DECISION DELEGATED TO DEVELOPMENT MANAGER

Application No:	H02-0901-18	Applicant:	Blackjack Estates Ltd
Proposal:	Proposed erection of 5 dwellings and garaging		
Location:	35 Peterborough Road Crowland Peterborough		
Terminal Date:	30th April 2020

C36 - 200

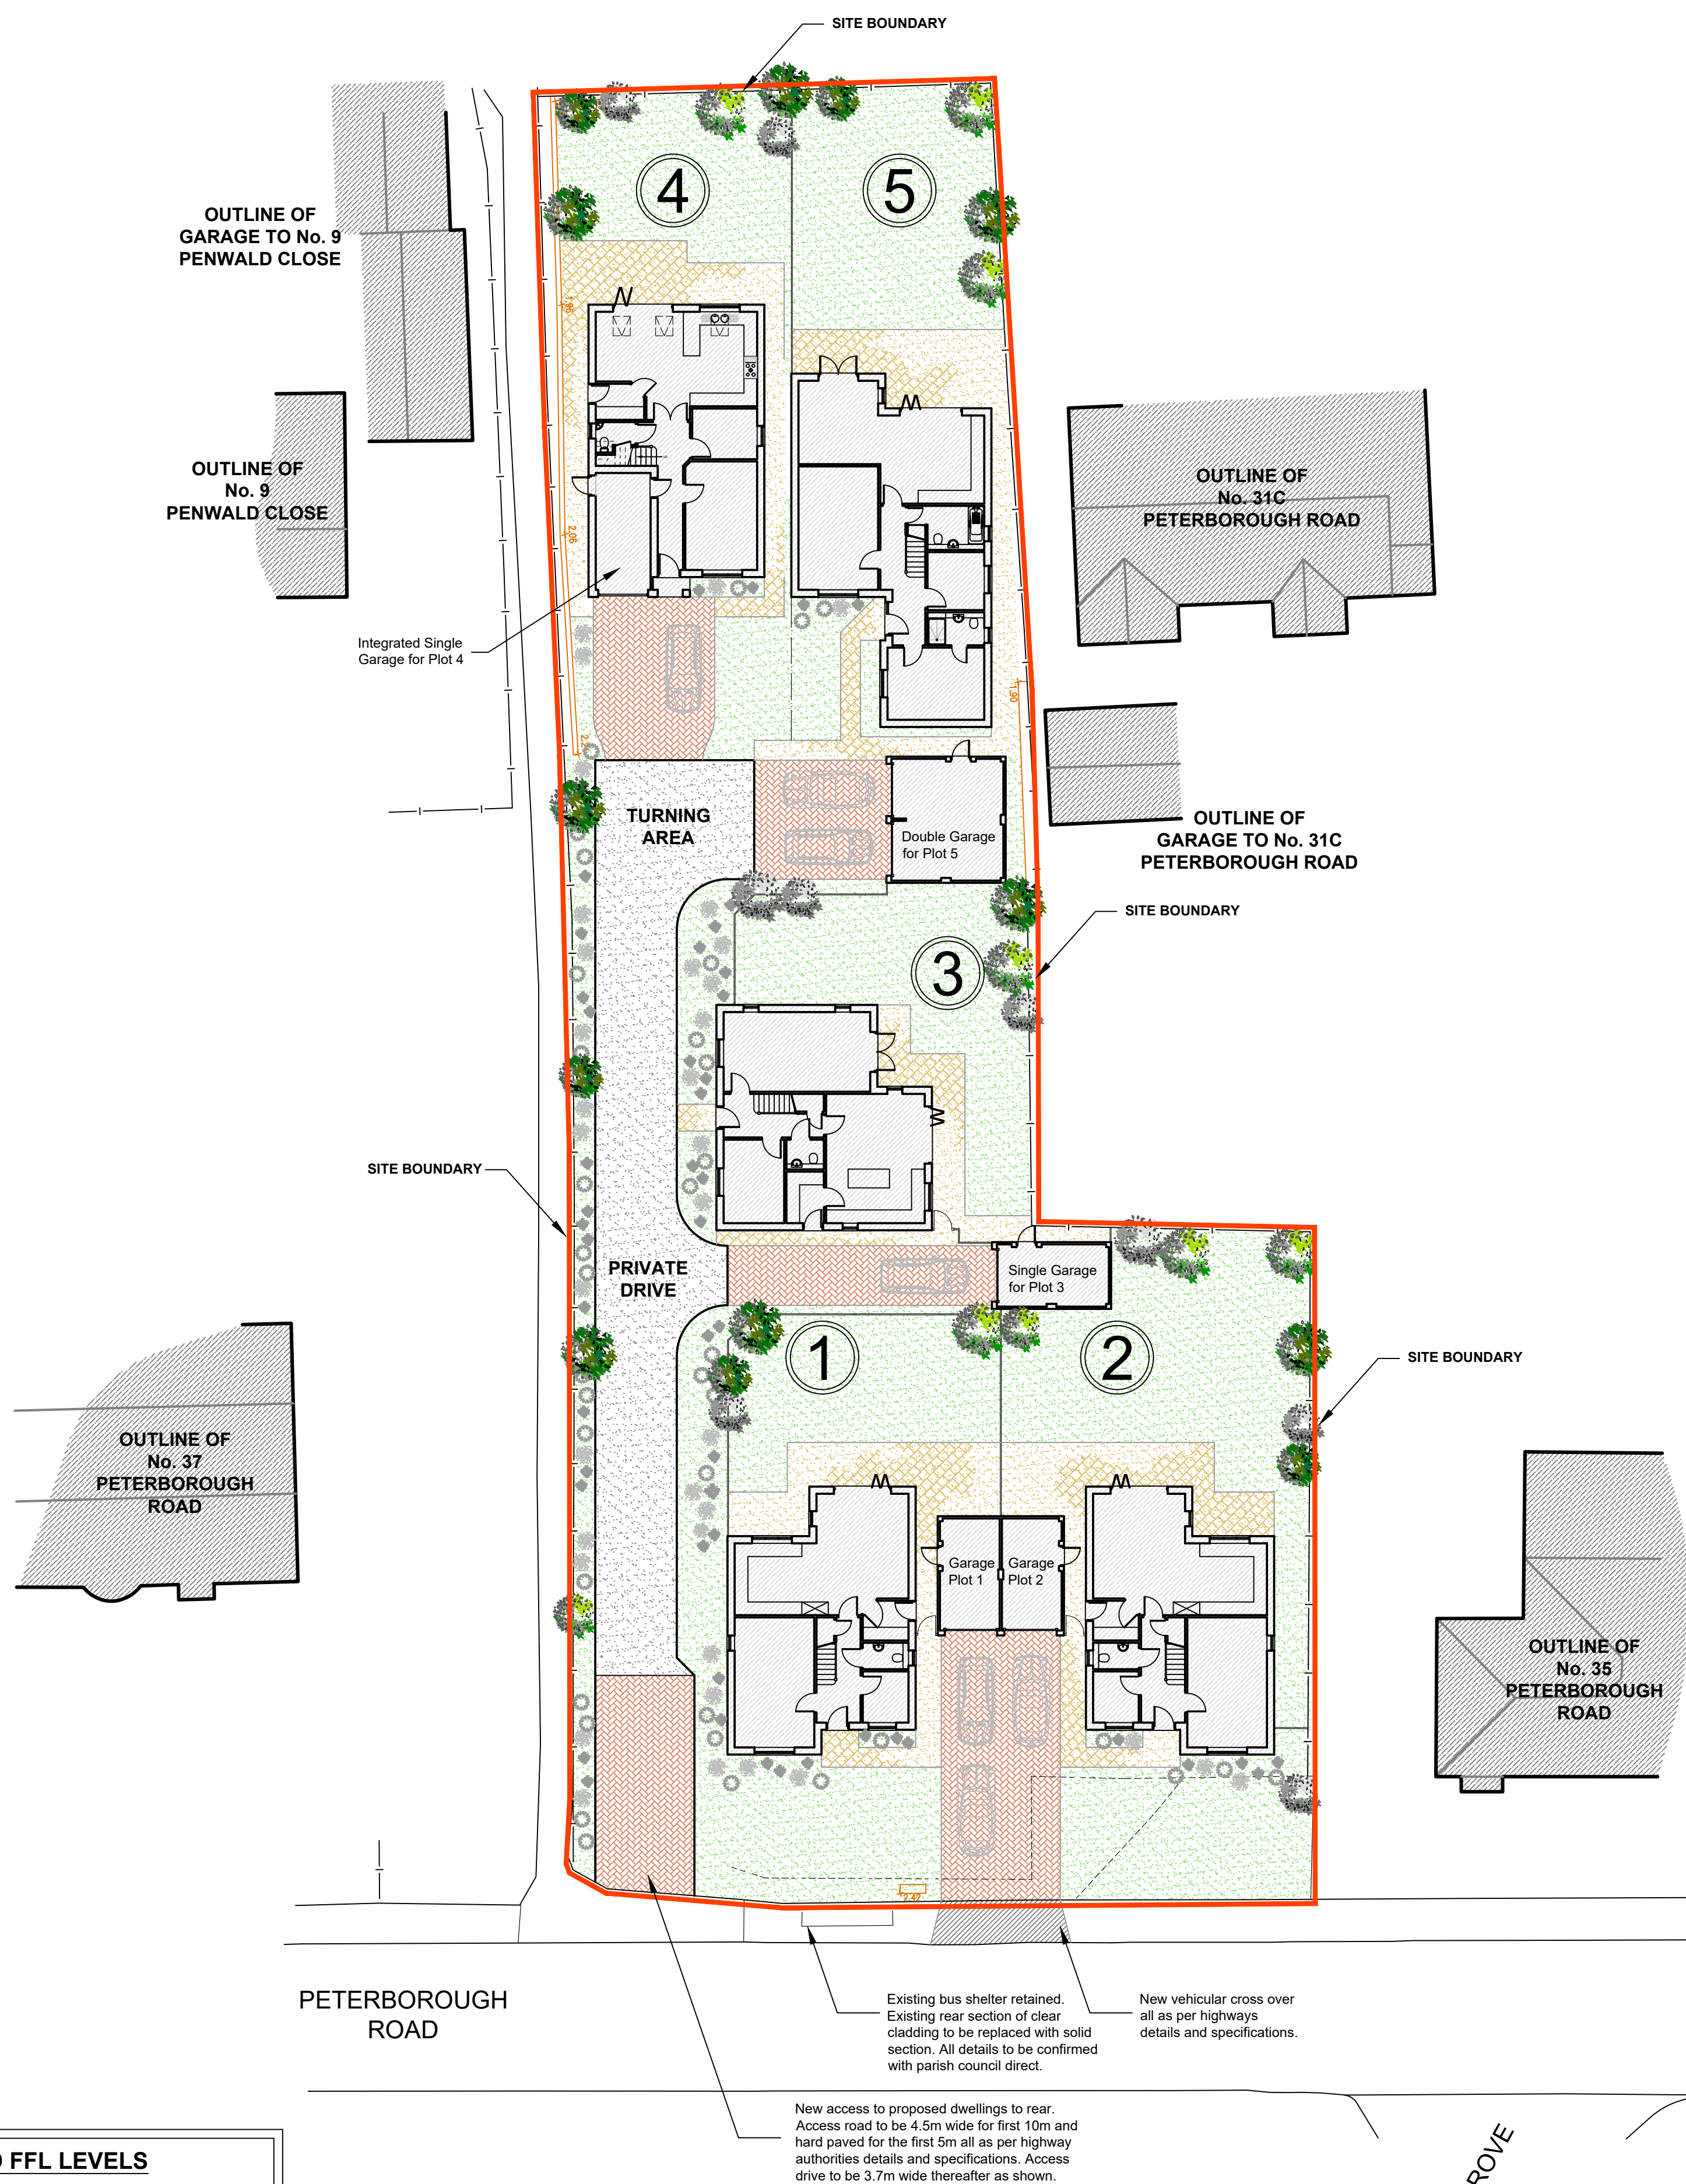
Vehicles can drive in but would find it difficult to turn around and leave in a forward gear. Plot 3 : Could drive past, then reverse back into their garage/driveway, (provided there were no other vehicle movements on the main access drive). Plots 4 & 5 : Would need to reverse onto each others' driveways in order to turn around and leave in a forward gear. Where would visitors park? How would delivery vehicles manoeuvre around the site.

The key issue to be considered in terms of residential amenity is the suitability of boundary treatments given the requirement to raise finished floor levels by 1m. No's. 31c and 35 Peterborough Road to the north both have windows on the southern facing elevations and both Plots 2, 3 and 5 adjacent have north facing windows. Given that exact proposed site levels are not known at this stage, it is considered that it would be prudent to include a condition requiring these details to be submitted prior to commencement of development to ascertain the height fencing would reach. Notwithstanding the fact that details of boundary treatments have been submitted with the application, a condition will be added requiring the submission of such details to allow consideration of this alongside site levels.

In terms of separation distances, there is an approx. 11m distance between Plot 4 and 6 Penwald Close and approx. 19m between Plot 1 and 37 Peterborough Road. Between Plot 2 and 35 Peterborough Road would be approx. 7m and 3m between Plot 5 and 31c Peterborough Road. Although there is a relatively small separation distance between the latter, Plot 5 would be a chalet bungalow and so it should not have a detrimental overbearing effect on no. 31c. The separation distances are therefore considered to be satisfactory.

Concern has been raised that there is not sufficient parking for residents within the site and that turning may be difficult. However, the Highways Authority have not objected on highways grounds and so it would not be reasonable to refuse the application on this basis.

All plots have two vehicle parking spaces within the curtilage plus a garage(s). This is in accordance with Appendix 6 of the Local Plan which requires a minimum of 3 parking spaces for dwellings for 4 or more bedrooms.
